Application for a Non-Material Amendment Following a Grant of Planning Permission

Non-material amendment application proposing a new circular window on the West Elevation (for the en-suite), to match other existing, circular windows, following planning approval PA21/11058.

PA21/11058

# Proposed First Floor Plan

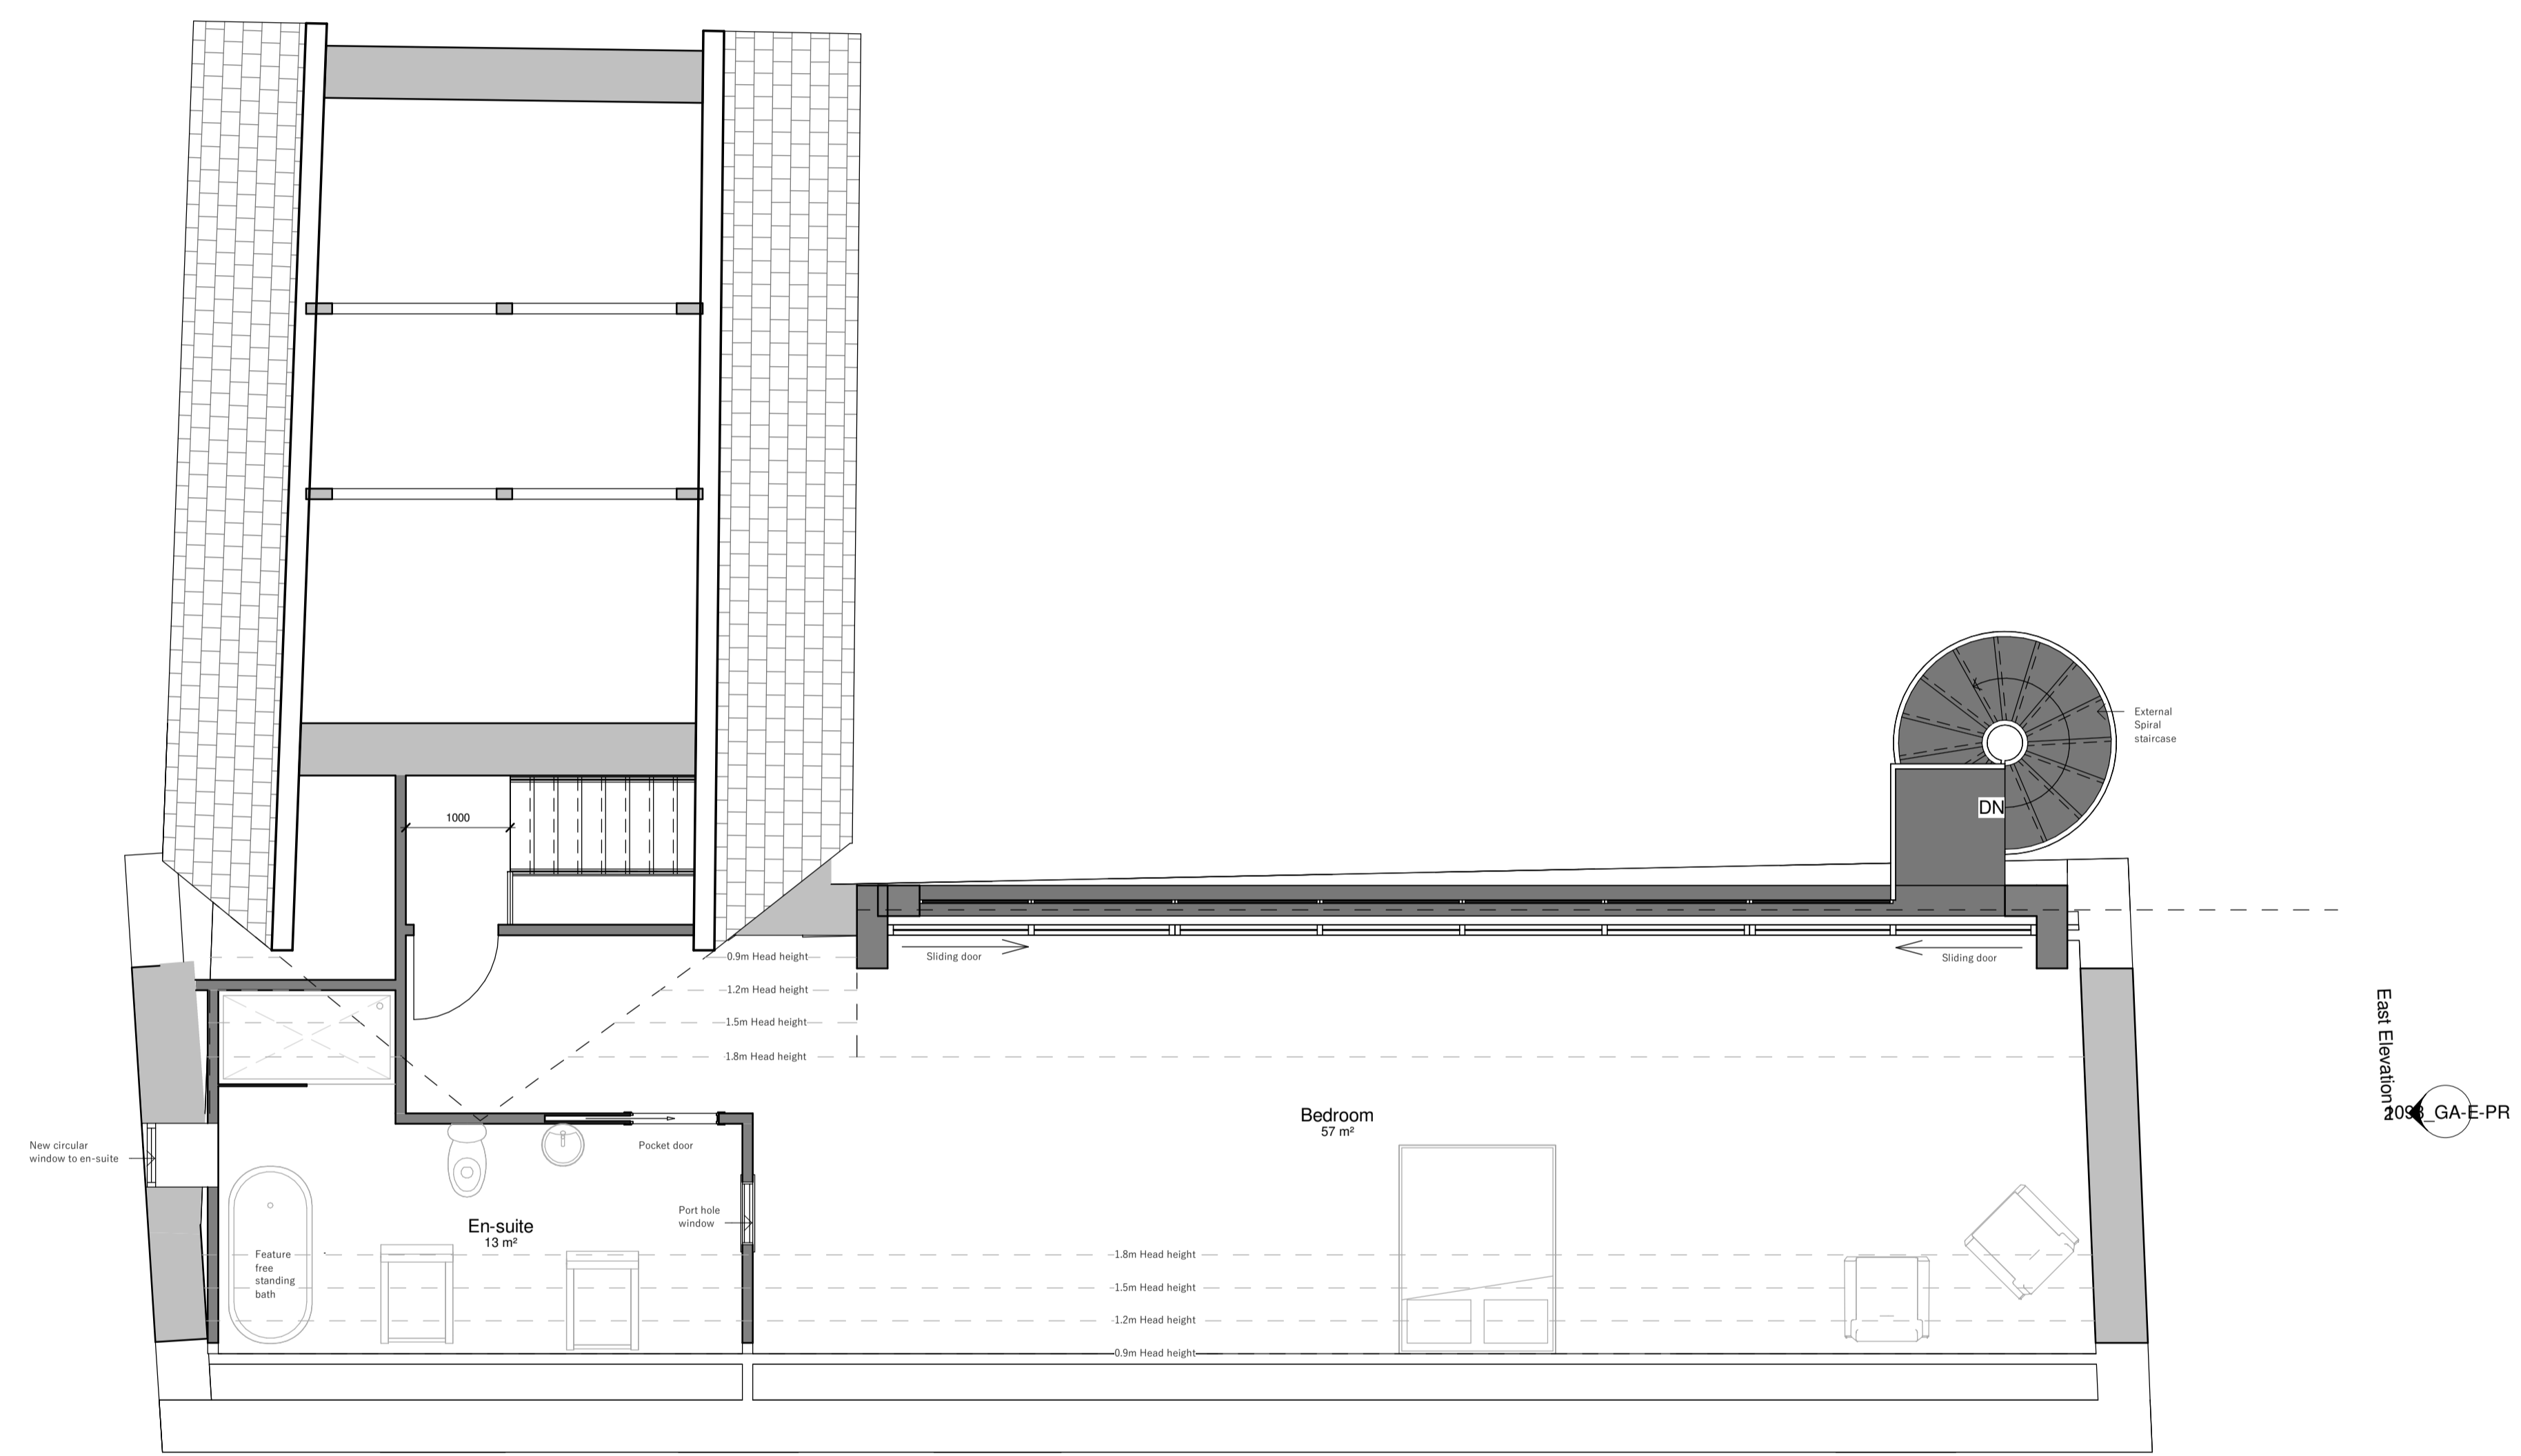
A new circular window to the West elevation, for the en-suite

West Elevation
1 : 100

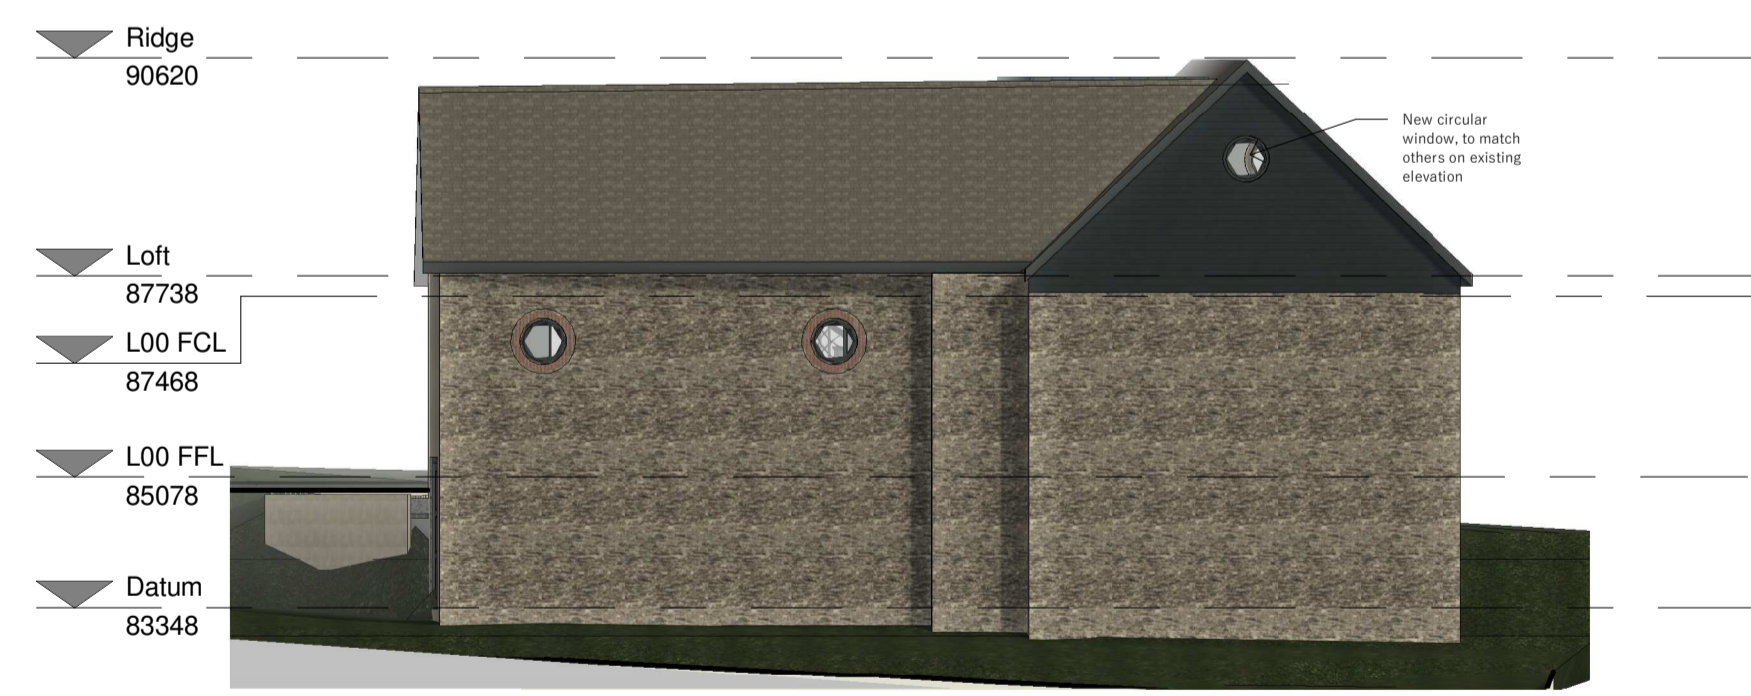
To give additional light to the en-suite.
